Application No: P/82/12/

Recommendation Report for Planning Permission for Works or Extension to a Dwelling

LOCATION: 24 Pagham Road
Pagham

PROPOSAL: Removal of existing workshop & conservatory. Construction of a single storey rear extension (East). New vehicle access to Pagham Road to provide 'in & out' vehicle movement for safety reasons

24 PAGHAM ROAD
PAGHAM
MR. & MRS. CASS
NEW DRIVE/ROOF PLAN
1:100 / 1:250
3207.O1 PL12

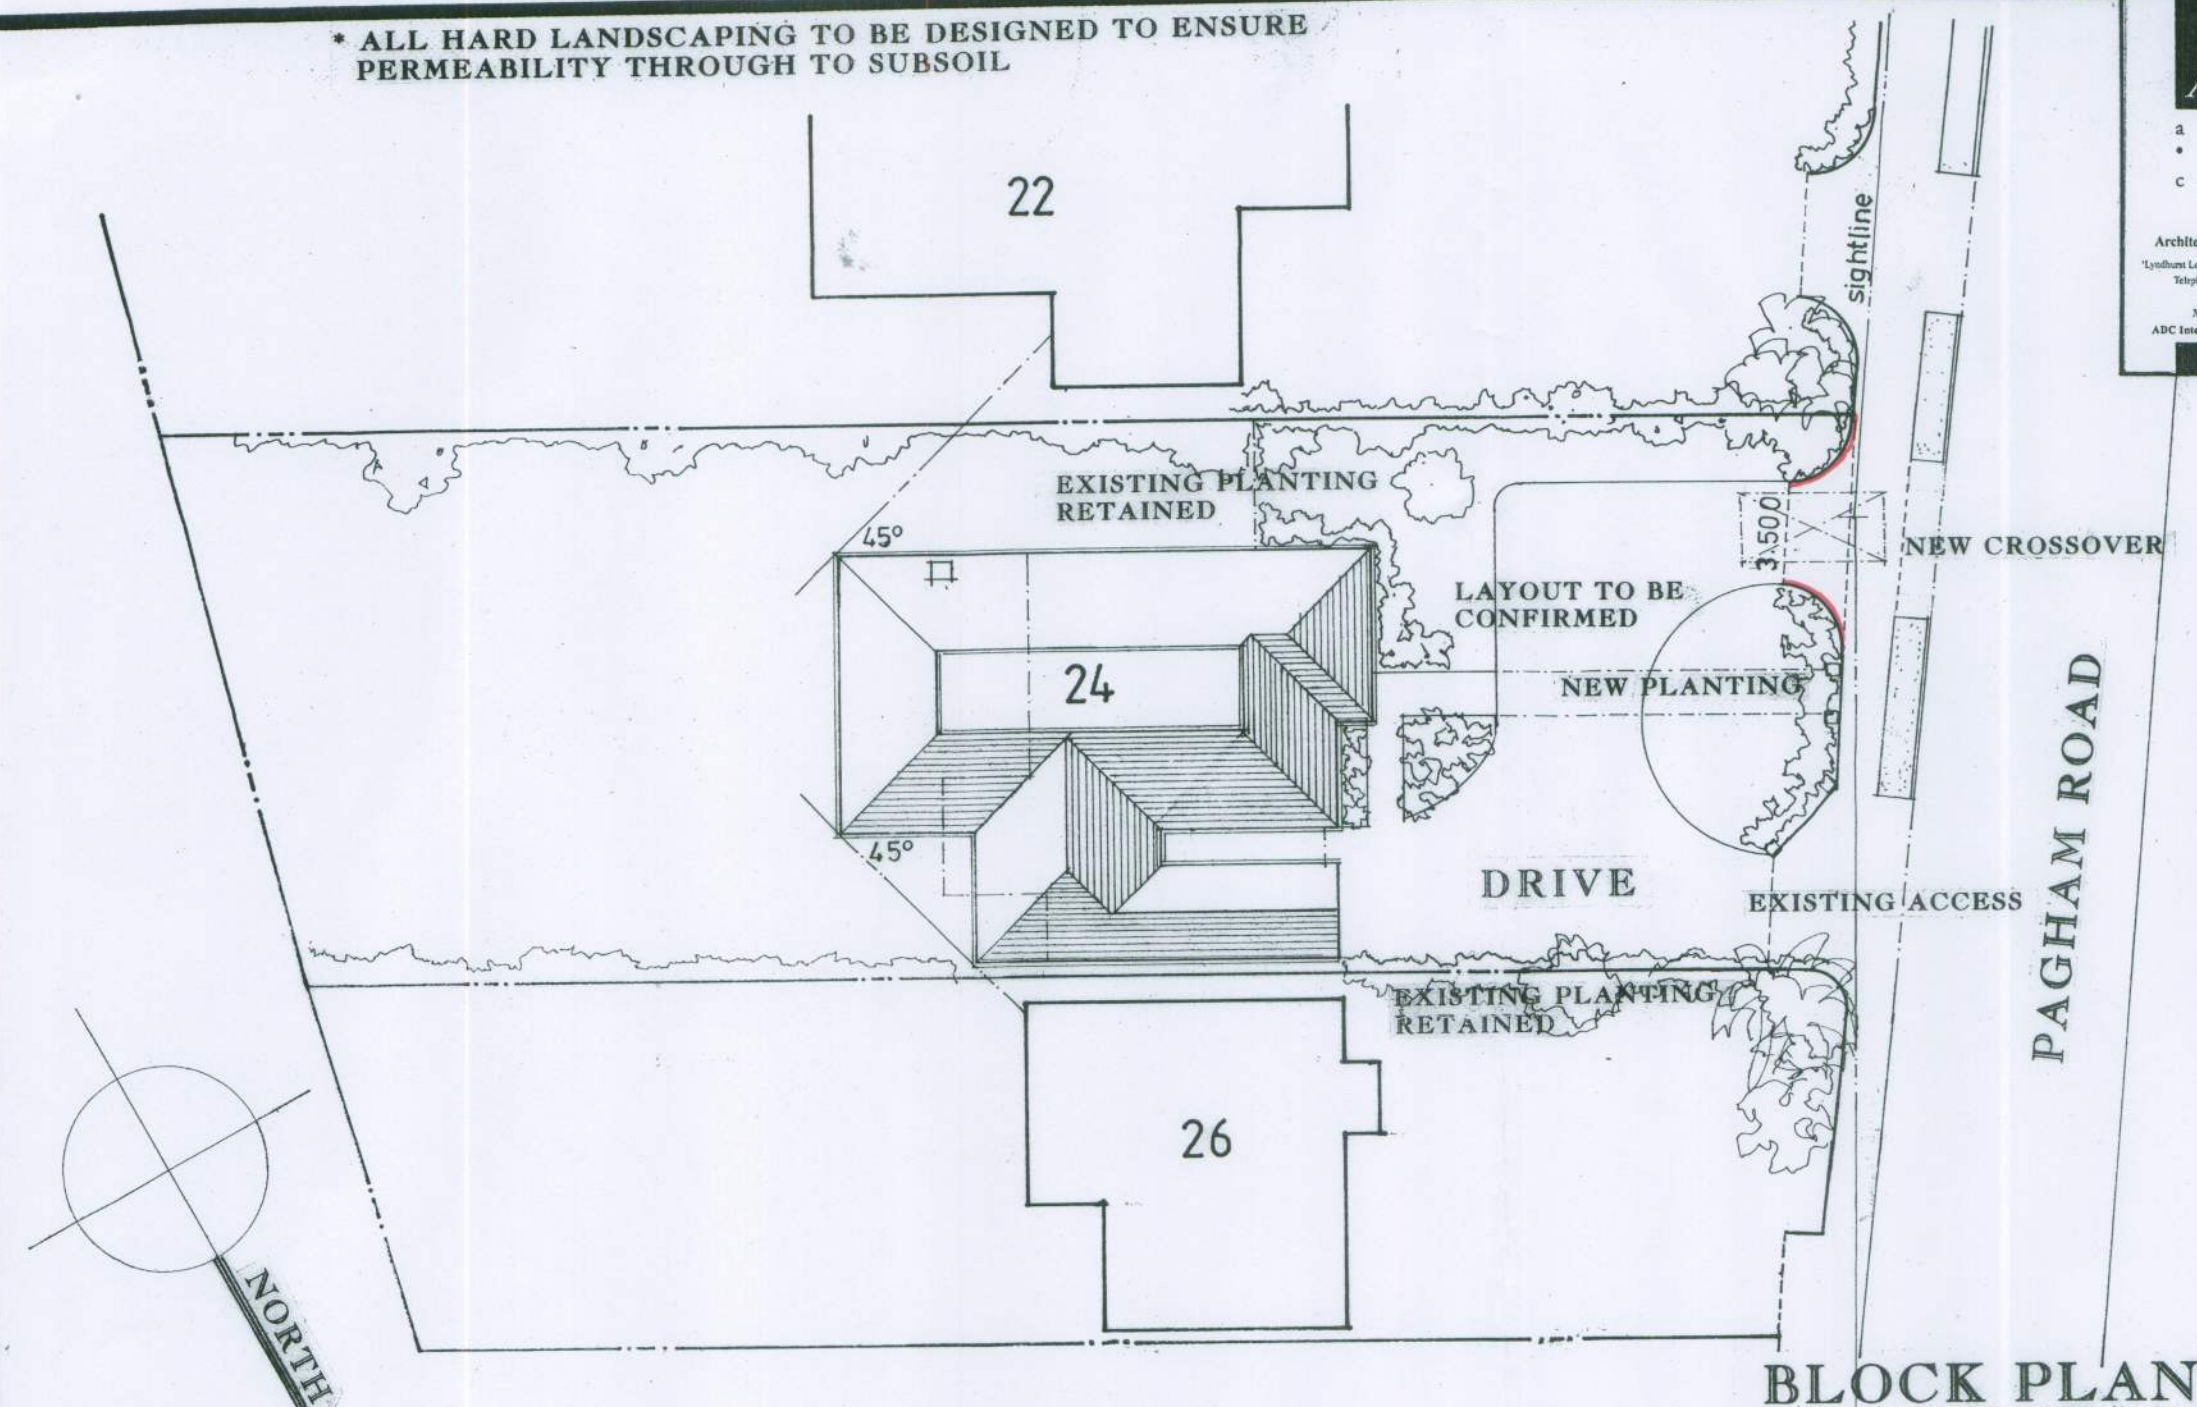
There is no apparent visibility issue at the proposed new access point, and given that an access already exists adjacent to it, would seem sufficient evidence to presume there are no concerns. The site lines to the east when exiting will also be enhanced from having the exit moved. The most recently available verified accident records reveal there have been no personal injury incidents in this direct vicinity. The provision of 2 x 2 metres pedestrian visibility splays should be secured by condition at this access point.

The existing access onto Pagham Road is narrow and not easy to negotiate and a second access is proposed that will allow for an 'in and out' system. This will require the removal of part of the front wall on the southern side to create a new access with crossover and the front garden is to be adapted by the provision of hard landscaping. County Highways have been consulted and have raised no objection on the proviso that 2 x 2 metre pedestrian visibility splays be implemented and this will be secured by a condition.

- 4 The new vehicular access to the proposed site shall be laid out to provide pedestrian visibility splays on each side of the access in accordance with plans and details to be submitted to and approved by the Local Planning Authority.

These splays shall be:-

2 metres by 2 metres on each side of the proposed access.

**24 PAGHAM ROAD
 PAGHAM
 MR. & MRS. CASS
 EXTENSION
 1:100 / 1:500 / 1:1250
 3207.01 PL11**

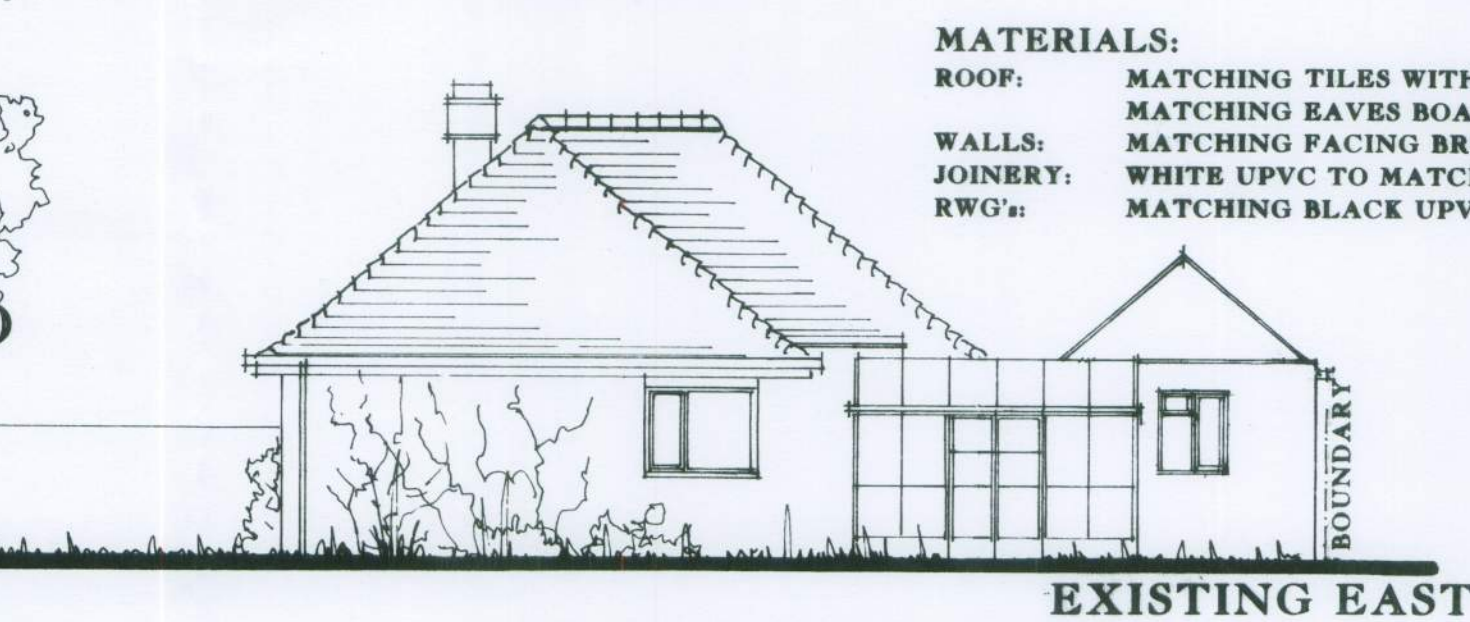
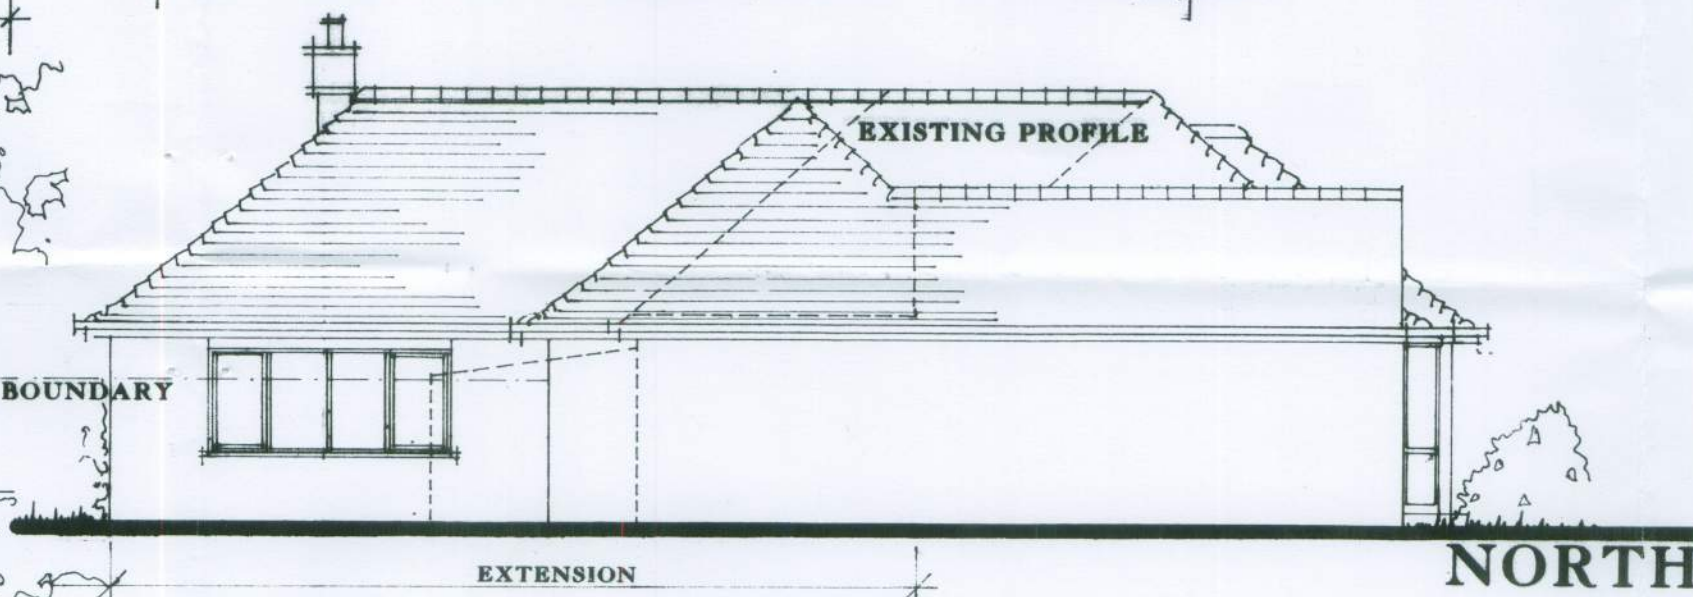
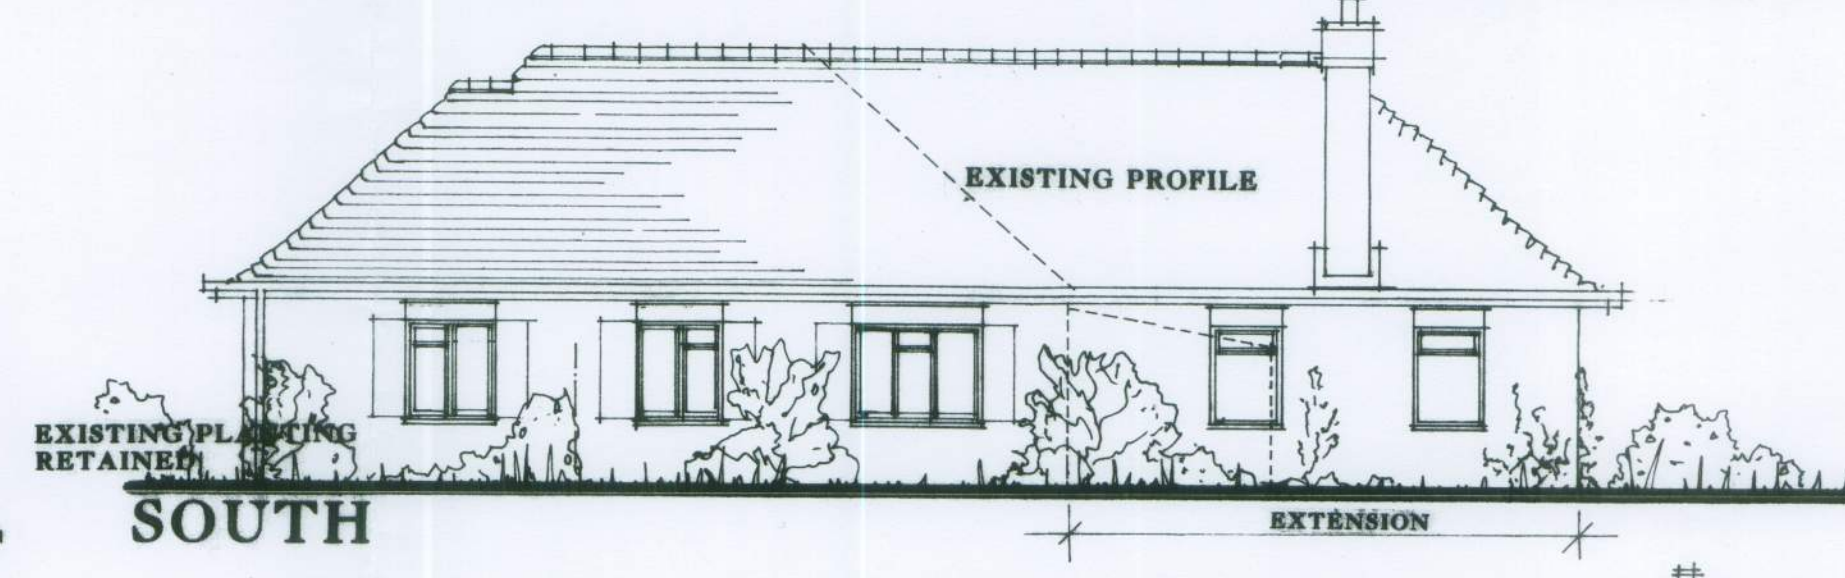
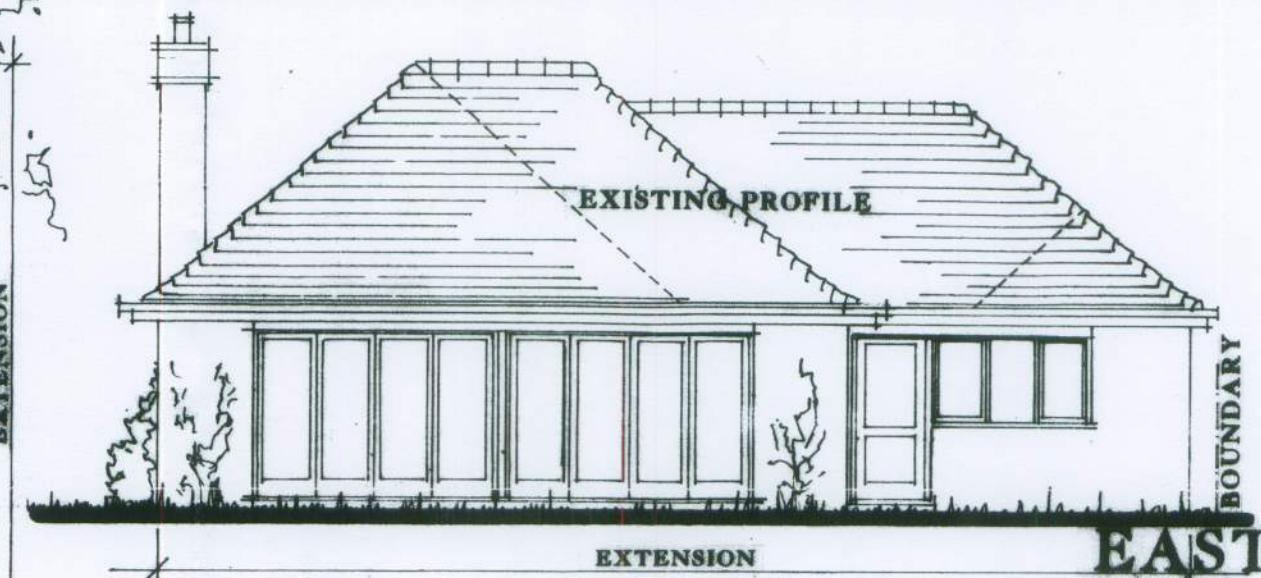
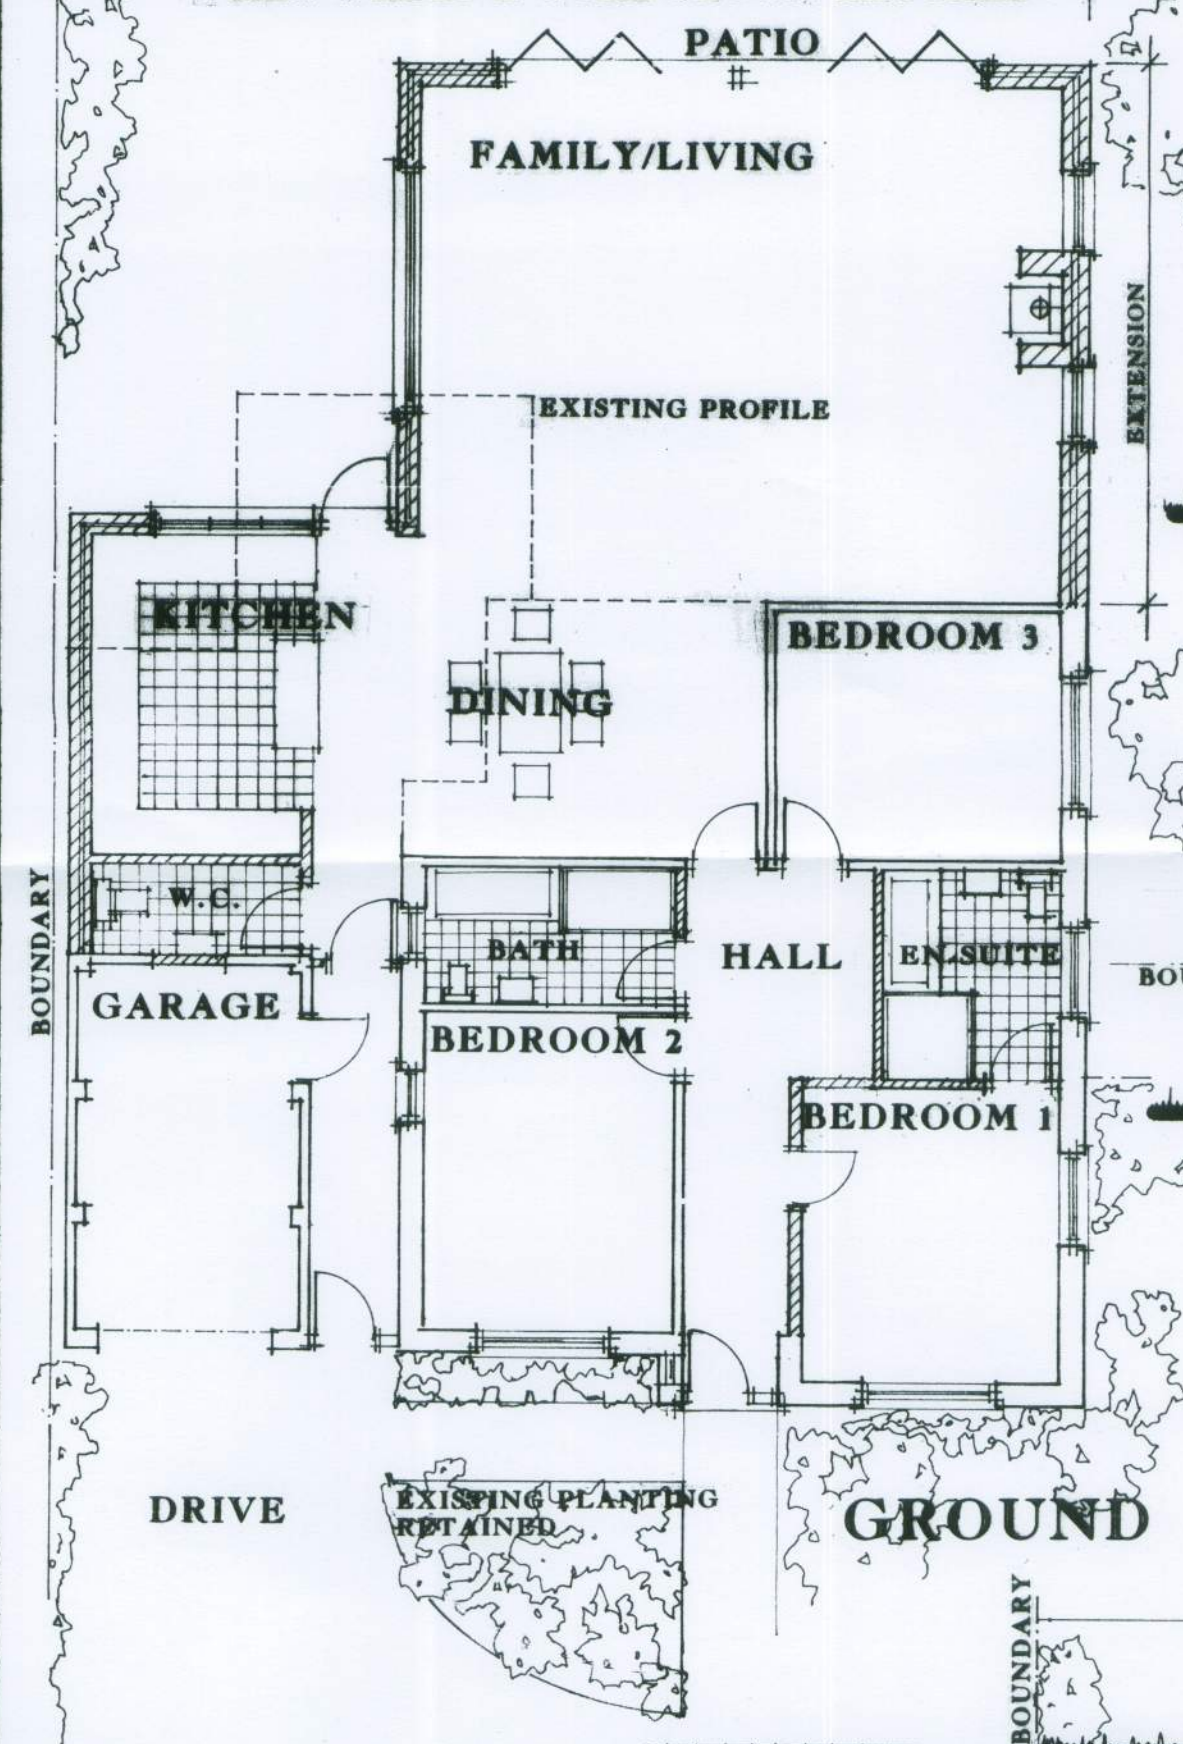
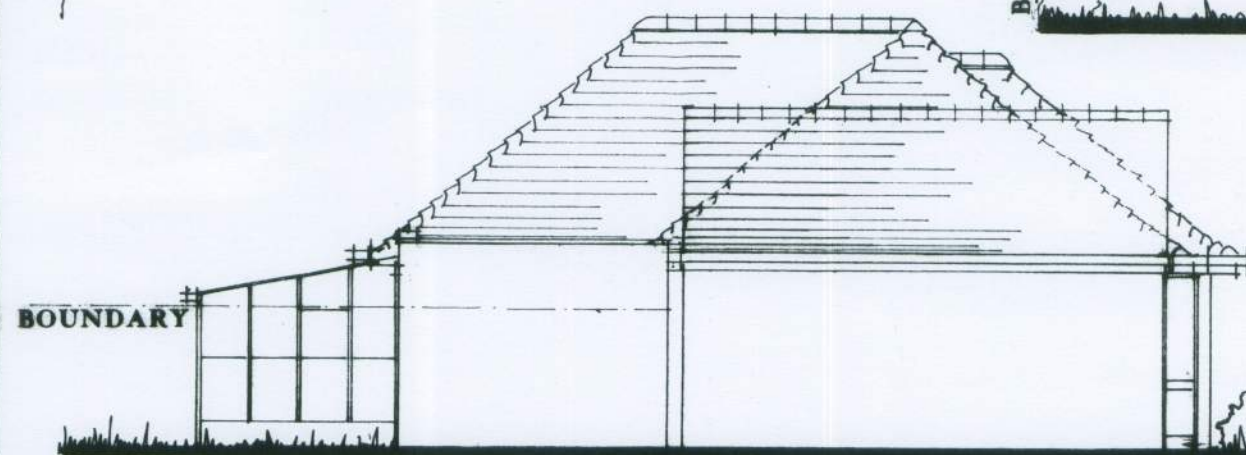
The proposal is considered to conflict with relevant Development Plan policies in that it does not accord with Policy DEV19(ii) in that it is not considered to be visually subservient to the host dwelling.

The property has a garage with workshop that is sited on the northern side of the dwelling and this is linked to the dwelling by a covered lobby and there is also a conservatory sited on the rear. The application seeks to retain the existing garage with the removal of the workshop to the rear. The rear conservatory is to be removed and a new single storey extension is proposed that will create a family/living room with a new pitched roof that will link into the existing roof and this will be no higher than the existing ridge height. Although the extensions are of an acceptable size and the new roof line will simplify the existing structure and remove existing valleys and gutters despite non-compliance with Policy DEV19(ii).

The neighbouring property to the north No 26 which is a two storey dwelling is sited approximately 1.5m away. The single storey extension has no windows on the side elevation and the property has a window on the rear. The neighbouring property to the south No 22 has recently been extended to the rear and this extension has two windows and patio doors on the side elevation fronting No 24. The proposed extension will be set in line with the extension at No 22 and on the south side elevation there are two windows. The 45% degree line has been taken from the centre line of the nearest neighbouring windows on No 22 and 26 and the extension complies with this rule. In view of its single storey height and adequate boundary screening it is not considered that the proposal would detrimentally harm the occupiers of No 22 and 26 by way of overbearing affect, unacceptable overlooking or loss of outlook.

- 3 Notwithstanding the provisions of the Town and Country Planning (General Permitted Development) Order 1995, no windows or other openings shall be formed in the roof slope without the prior permission of the Local Planning Authority on an application in that behalf.
